DECISION DELEGATED TO HEAD OF PLANNING

Application No: H16-0004-23 **Applicant:** Mr & Mrs J Brown
Proposal: Proposed detached car port & alterations to dwelling
Location: 45 Woolram Wygate Spalding
Terminal Date: 1st March 2023

Client	MR & MRS J. PROGNL		
Drawing	FLOOR PLANS & ELEVATIONS SITE & LOCATION PLANS		
Job Ref.	4091-22	Drawing No.	01B.
Date	DECEMBER 2022	Drawn	SLD

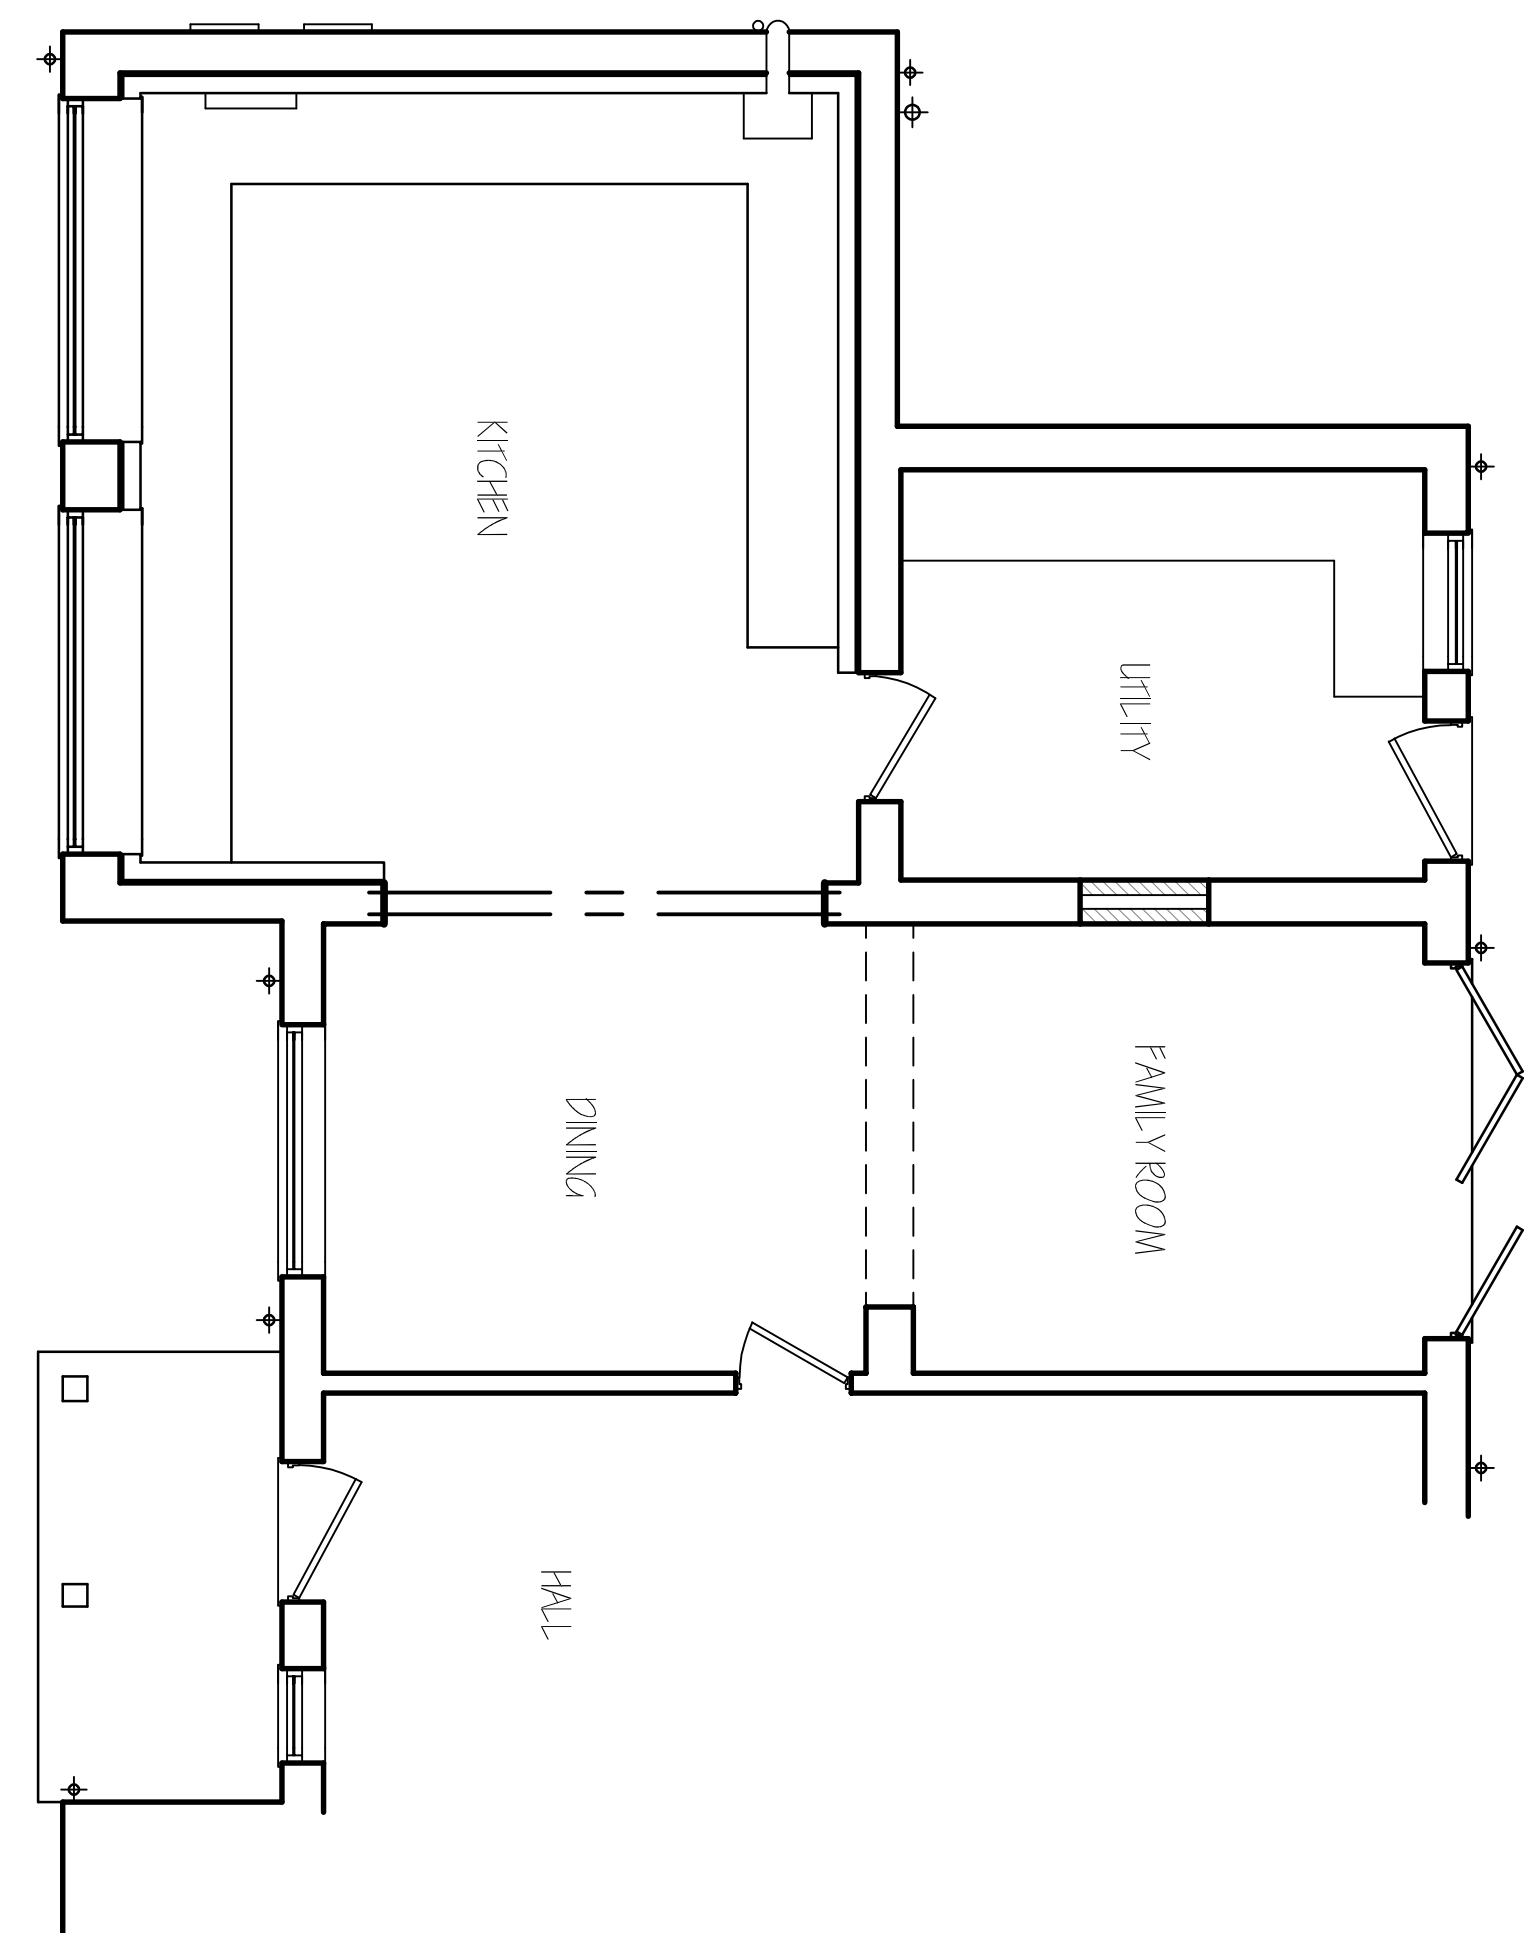
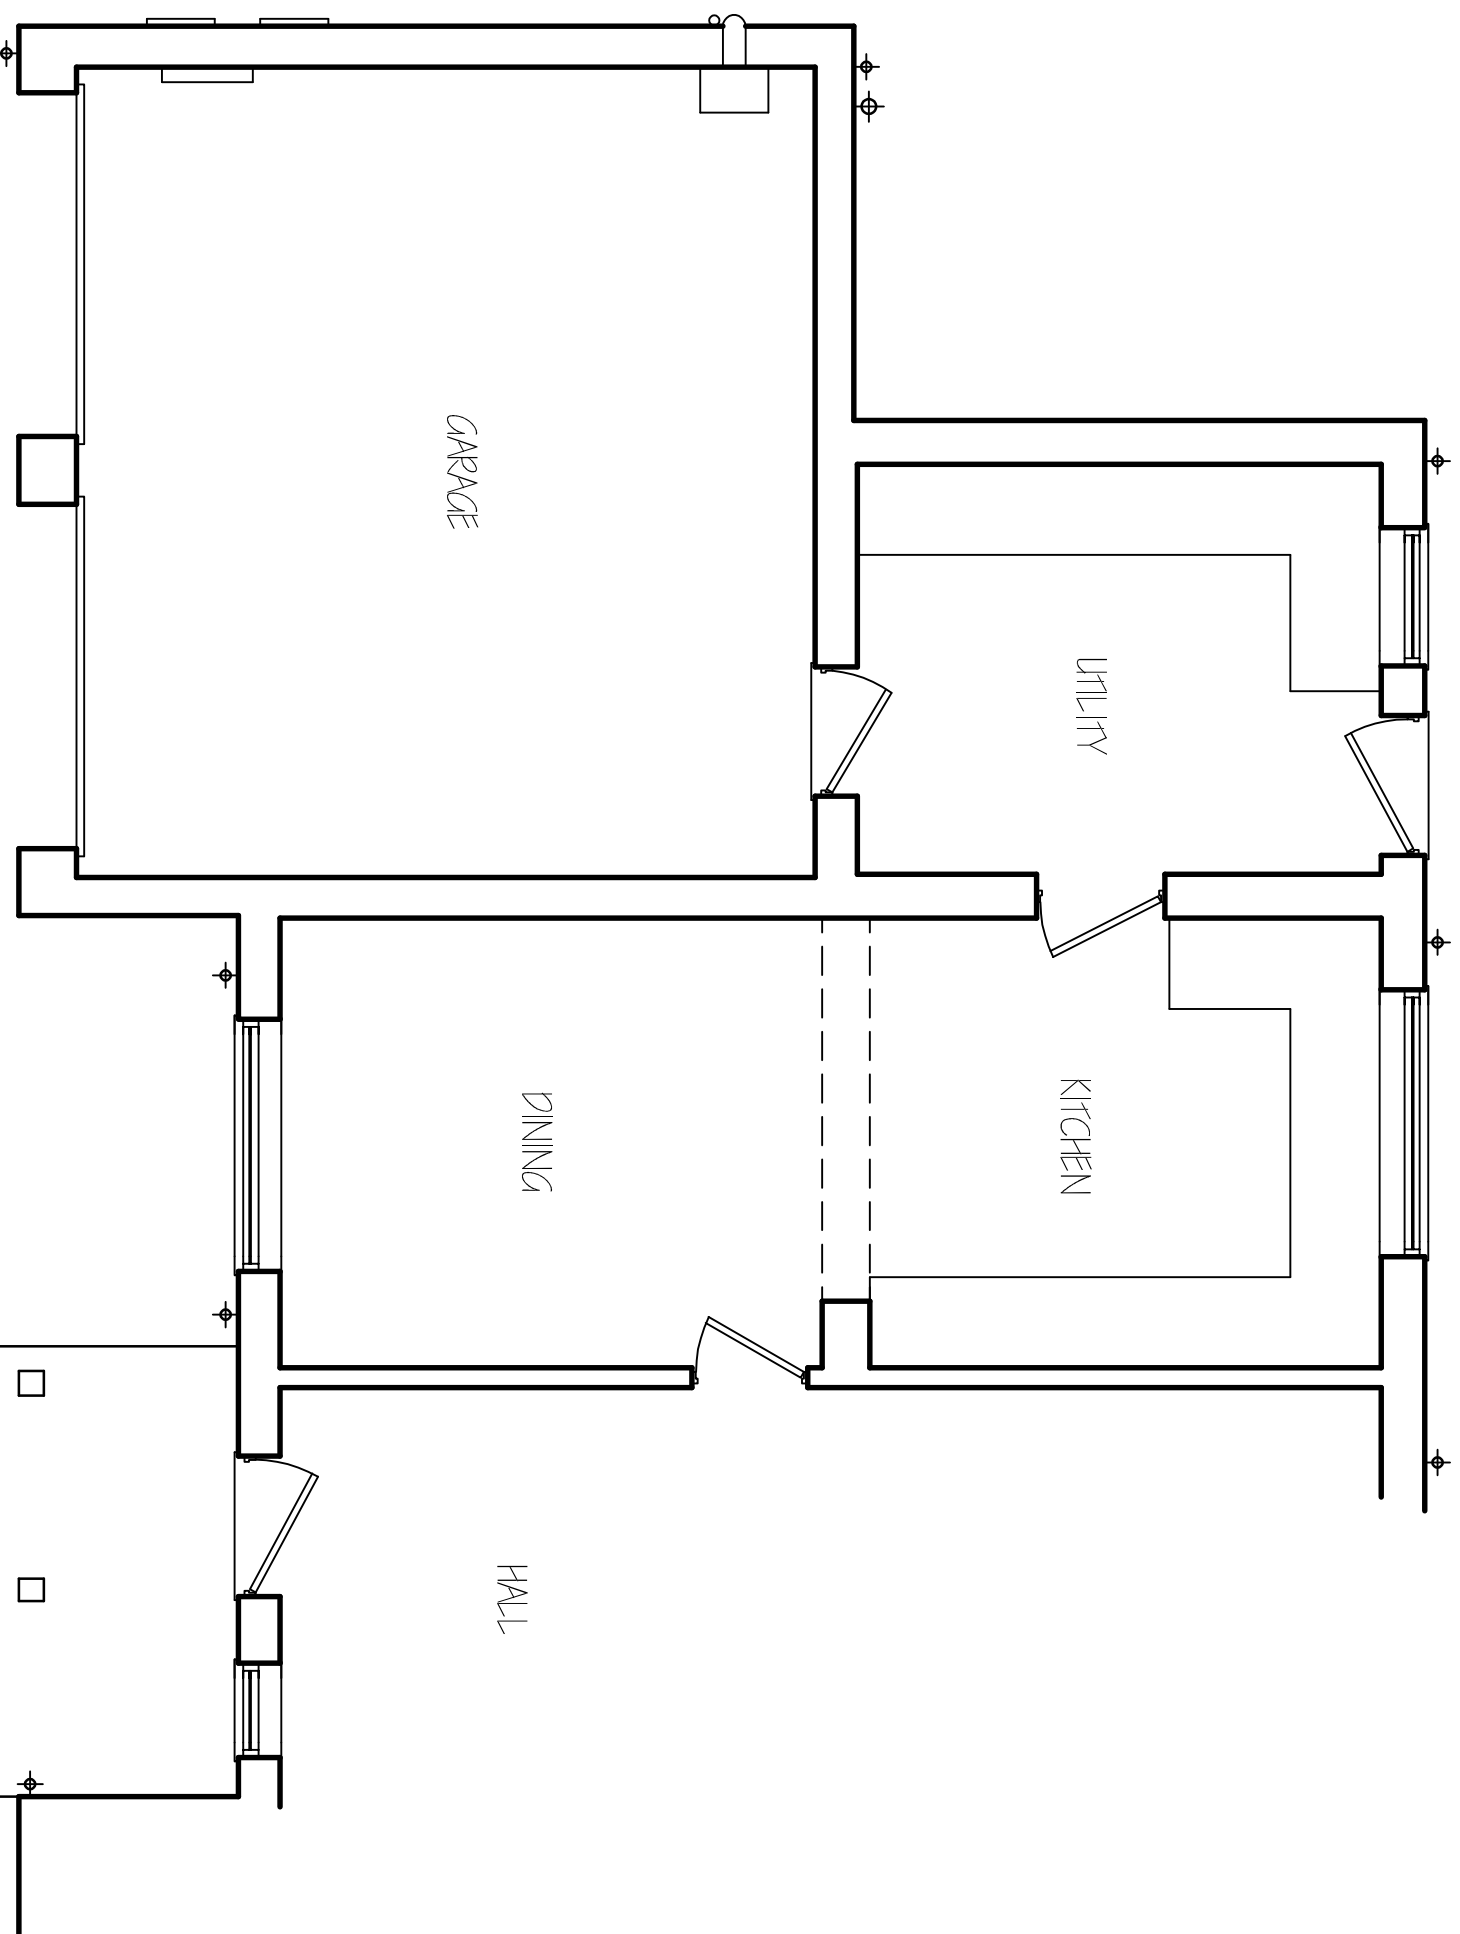
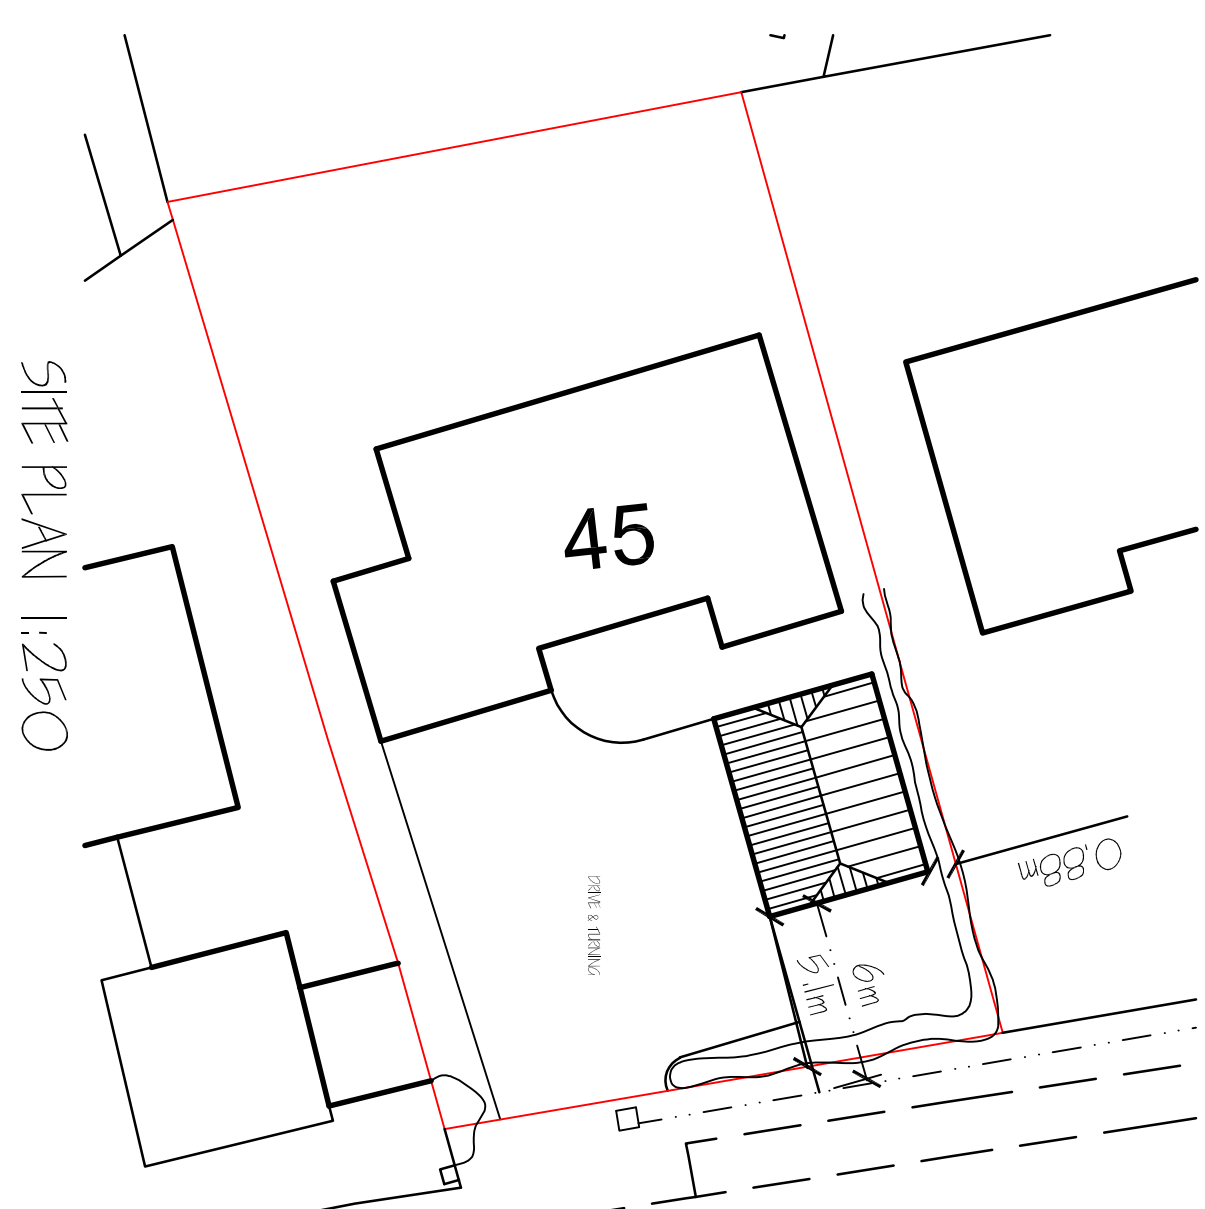
The proposed black cladding would create a prominent visual contrast with the street scene as a whole. Currently, black cladding is used as a feature material on the property's windows. Similar black highlighting is seen periodically on properties in the wider area. Despite this modicum of black cladding, the material is not established enough as to assimilate the proposed design into the location. Therefore, the proposed car port would create a visual conflict with the wider area and would not be in keeping with the sense of character of the neighbourhood.

The floor area of the car port is not deemed excessive. It would be comparable in size to its counterparts in the community. However, the height is considered excessive. It would add to the prominence of the design and would result in an incongruous and alien feature.

The significant height difference between the proposed design and the existing boundary treatment means there is the potential for overshadowing on the property to the north (47 Woolram Wygate). Due to the small distance (880mm) to the boundary, the potential for overshadowing is considered significant. The carport would prevent light entering the southern ground floor window of 47 Woolram Wygate. This window connects onto the 47 Woolram Wygate's living room. As such, any loss of light would be felt severely. These comments have been echoed in the comments and objections of the neighbours.

The Internal Drainage Board previously raised objections to the proposal, stating that the proposal would infringe upon the nine-metre distance of the Board's Woolram Wygate School Dyke pipeline. This was in direct contradiction of Byelaw 10 of the Internal Drainage Board Development Control Byelaws.

These concerns were addressed in the amended plans, which created a six-metre separation distance between the pipeline and the carport. This distance was agreed with an approved by the Internal Drainage Board.
